As per Adrian's email yesterday we are happy with the partial discharge of condition 18 to allow for demolition to commence, to satisfy the highways comment.

Thank you for the conversation on the phone today. I hope I was able to clarify and update you where we are with this application. So as to assist Mrs Gardner with a full analysis of the issues outlined to you the following additional information is requested:

16. Site Plan and Associated Drawings/Photographs

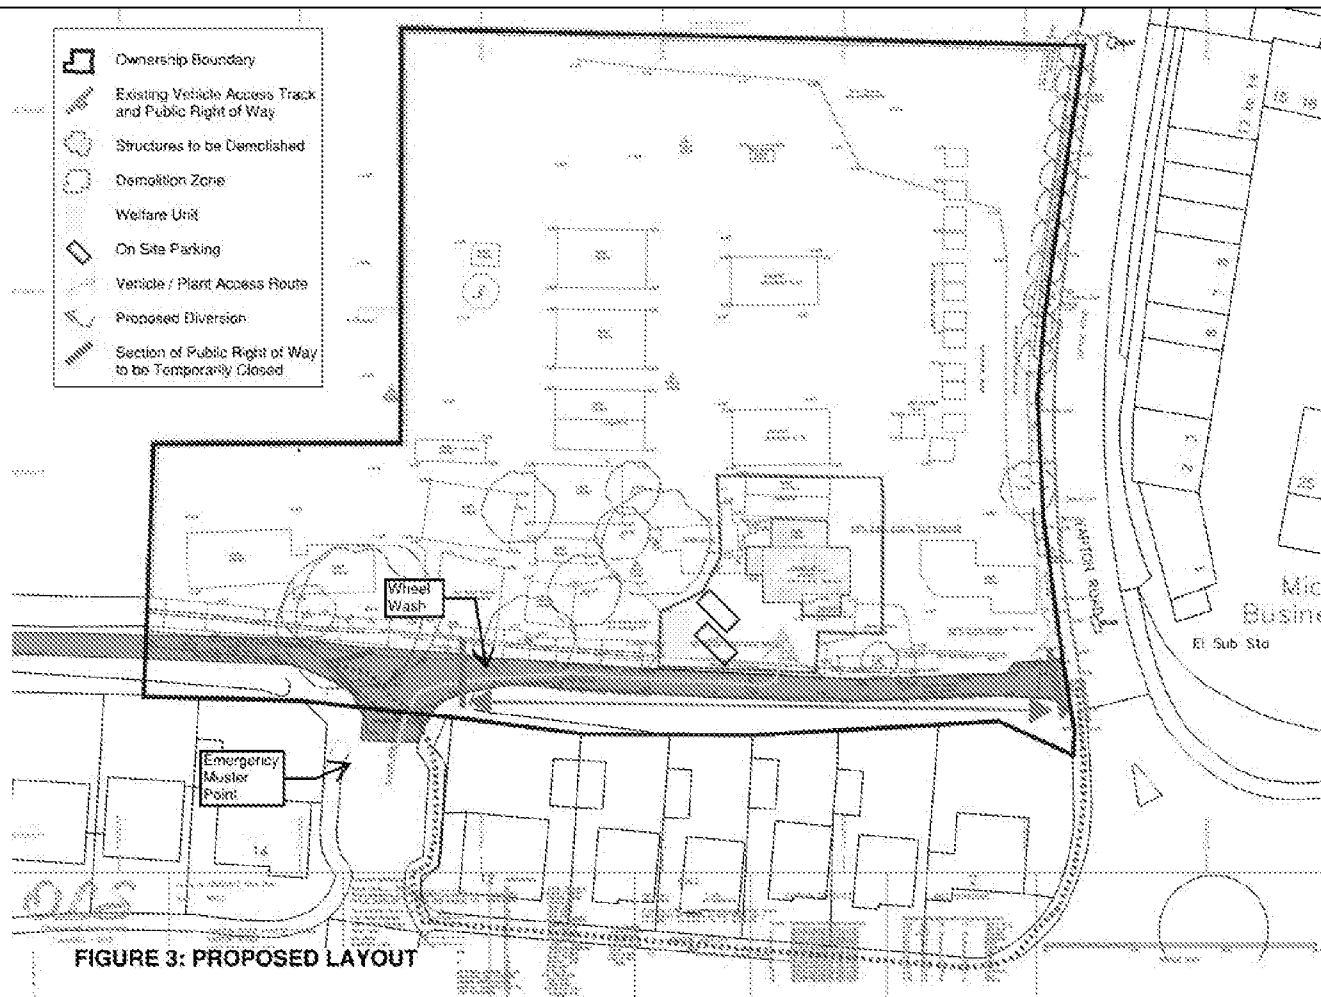
Please find herewith the updated method statement, in response to the comments raised by environmental health we have now included a solid hoarding along the residential boundary.
